Reference No:	2025/70/92338/W
Site Address:	Land at Lingards Road, Slaithwaite, Huddersfield, HD7 5HY
Description:	Variation of condition 2 (plans) on previous permission 2020/93954 for erection of 42 dwellings and associated works
Recommending Officer:	Katie Chew

DECISION – Section 73 Variation of Condition – Approve

Officer Report

Proposal: Variation of condition 2 (plans) on previous permission 2020/93954 for erection of 42 dwellings and associated works.

REV	Comment	date	project:	title:	REV
R01	Additional car park space added	25.09.19	Lingard Road, Slaithwaite	Proposed Floor Plans	R01
			Plot 24	Plot 24	
			client:	drawing status:	
			SB Homes	Planning	
			scale: sheet: date:	drawing no.: rev:	
			1:100 A1 August 2025	2510-PL-24-100 -

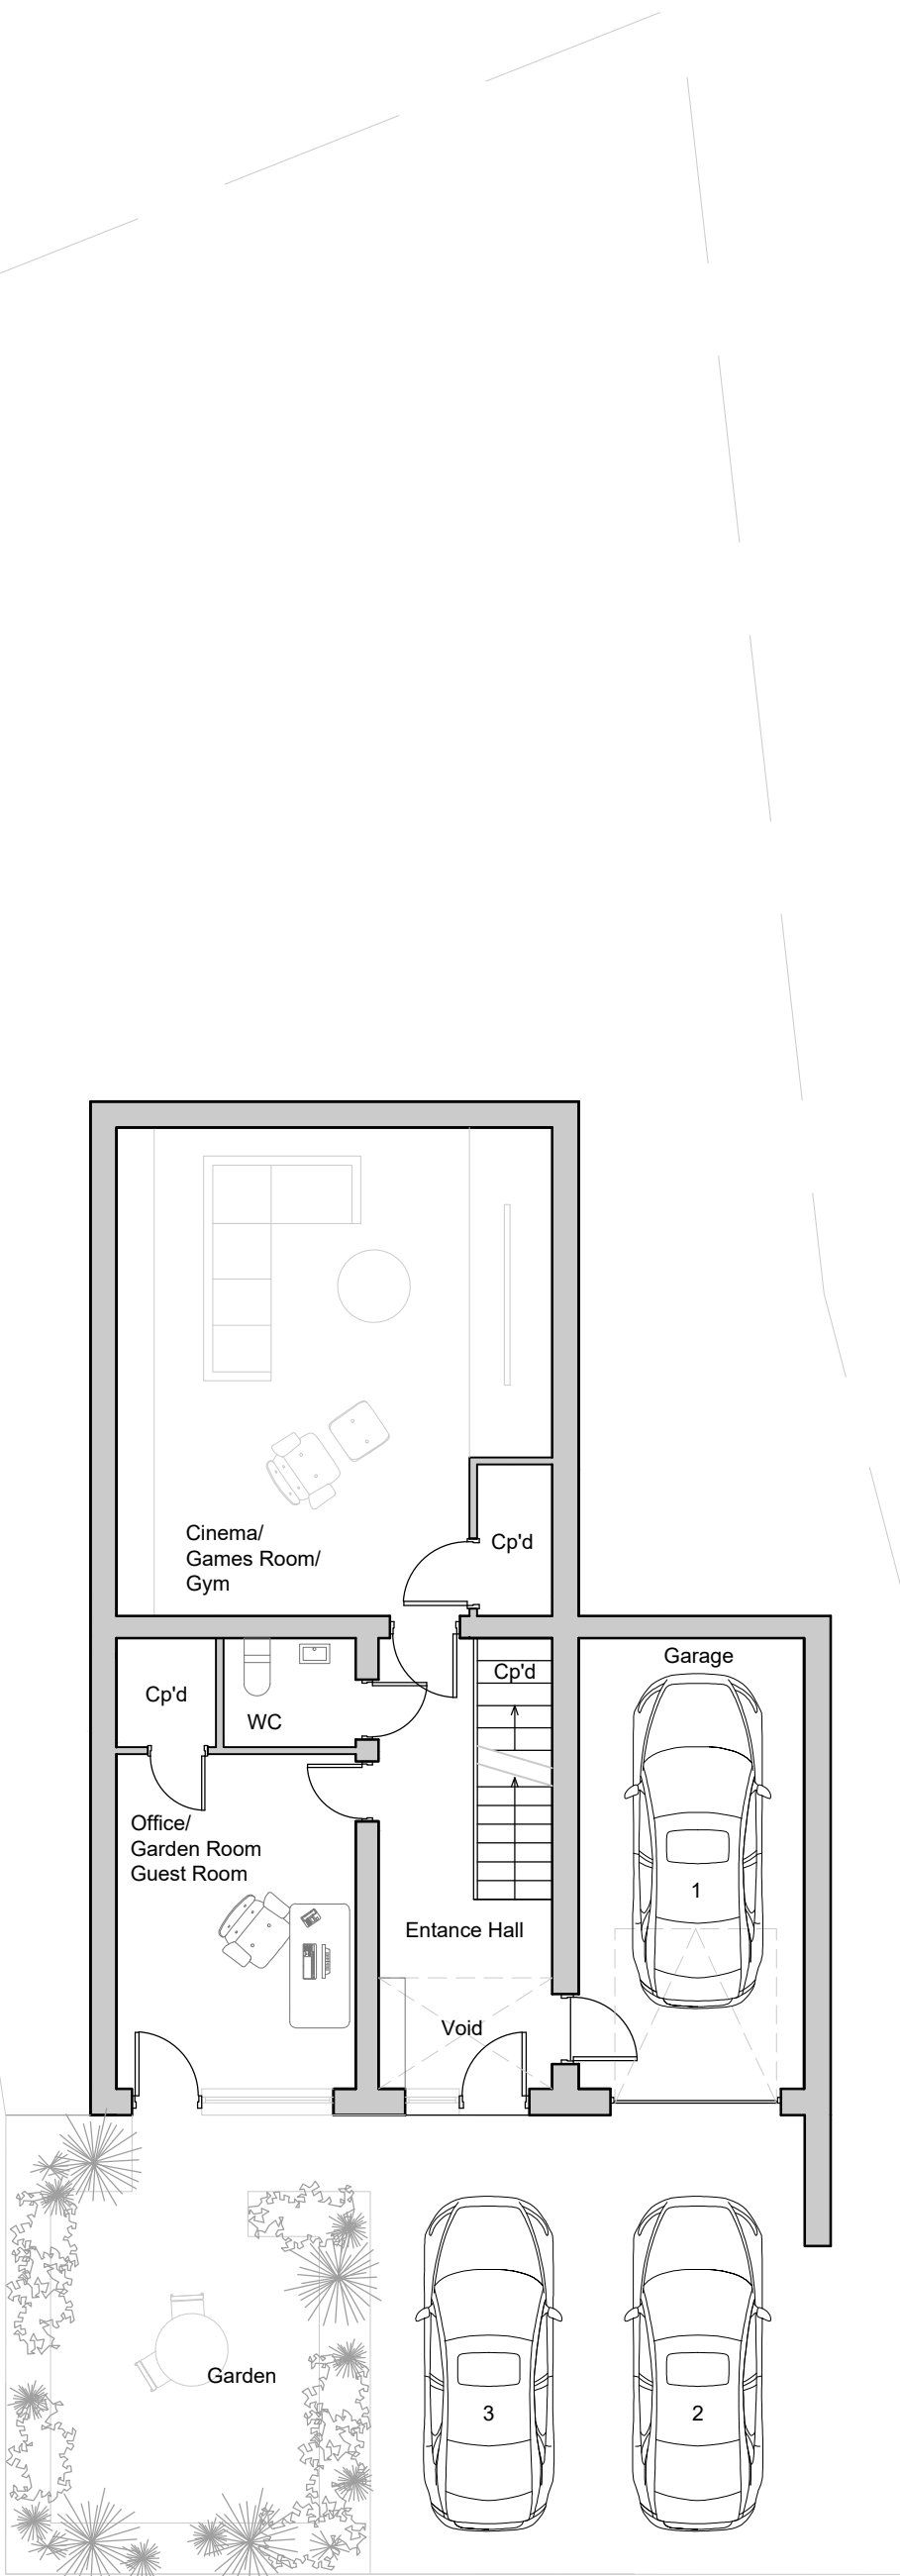
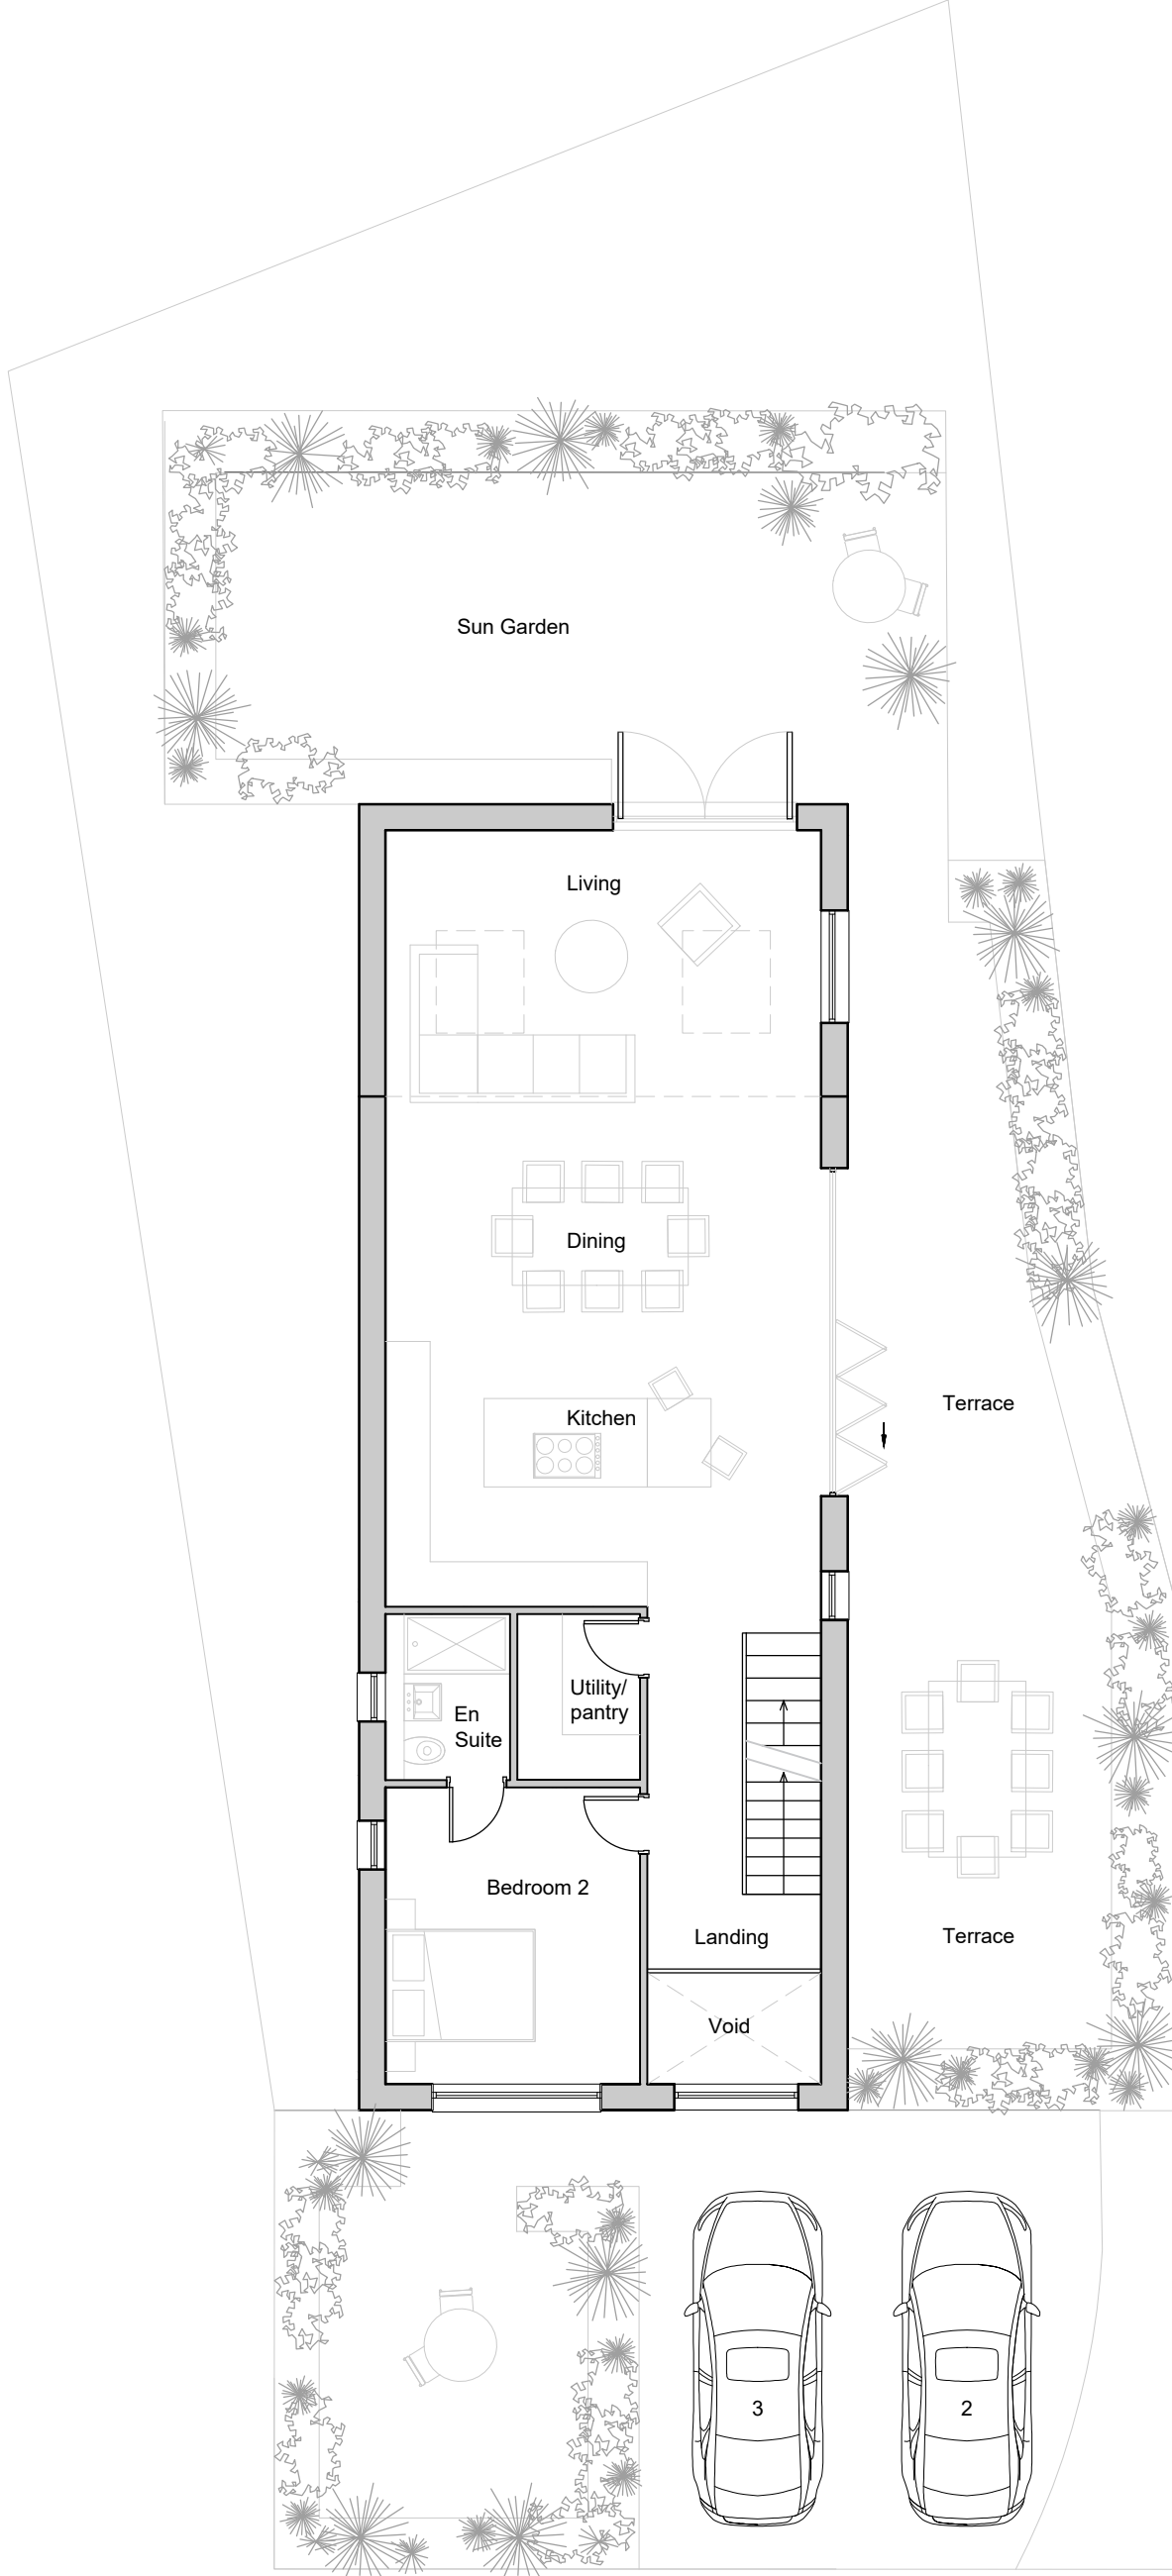
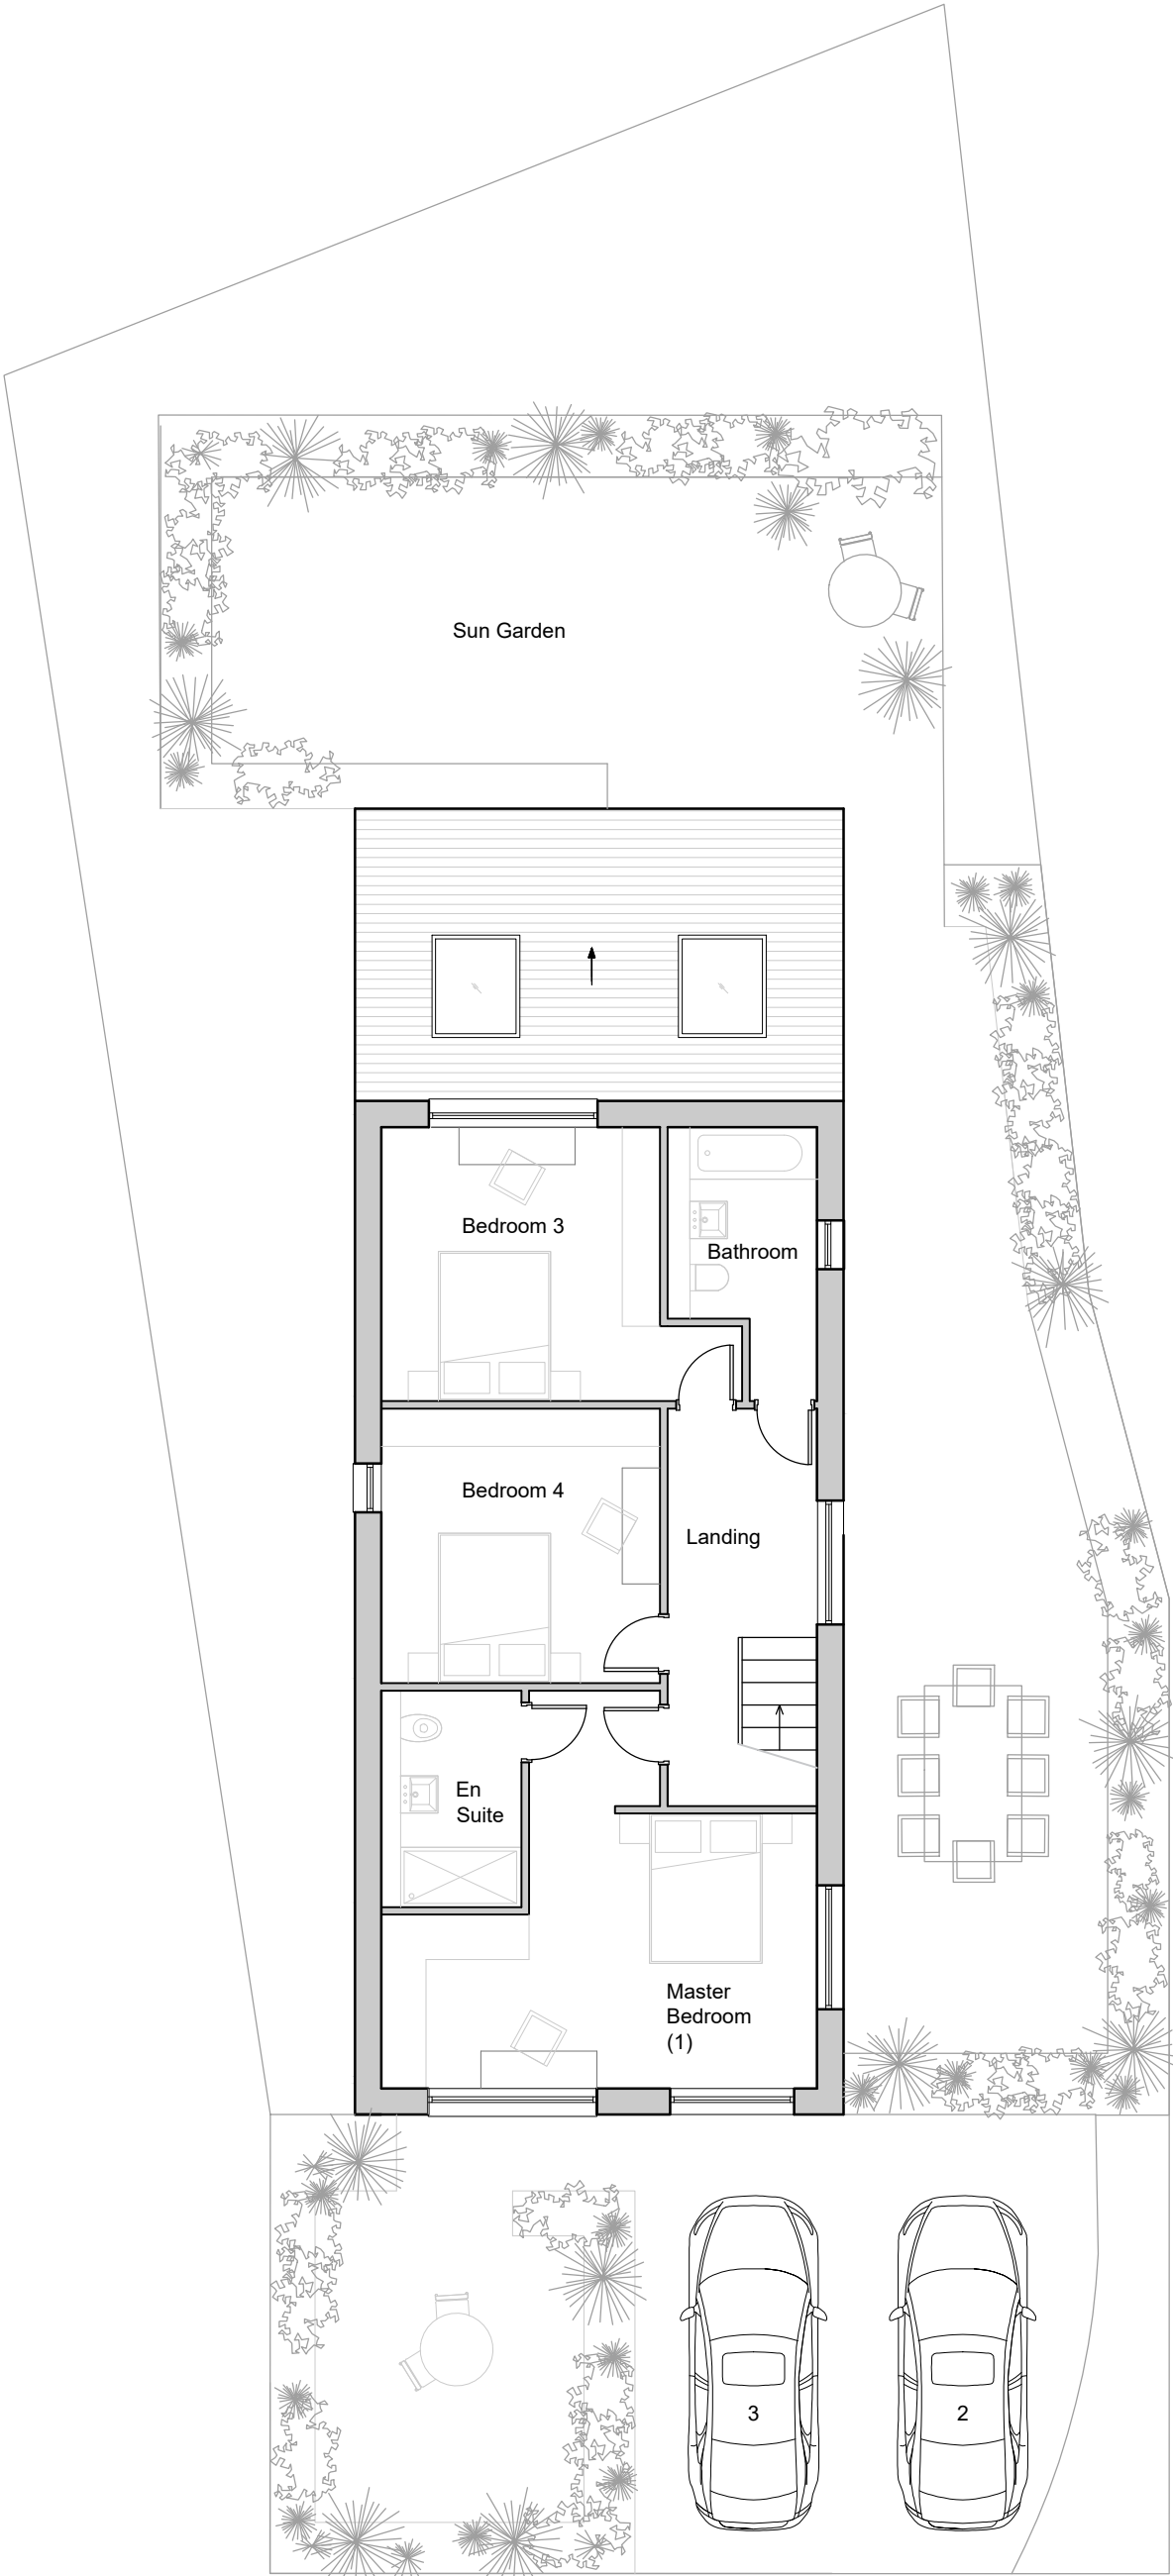
- Concerns over design inconsistency, notably the second floor en-suite door is shown to open inwards, whilst the first floor en-suite door opens outwards. This inconsistency suggests a lack of coordinated design logic and undermines the credibility of the submitted plans. This is also considered a building regulations compliance risk as door swing direction must be carefully considered in relation to safe egress, emergency access, internal circulation and usability and avoidance of obstruction or entrapment.

Officer note: The above comments are noted, and the applicant's agent has provided revised plans to amend this. However, Officers do note that the internal openings of the dwelling are not considered to be a material planning consideration and would be dealt with at building regulations stage.
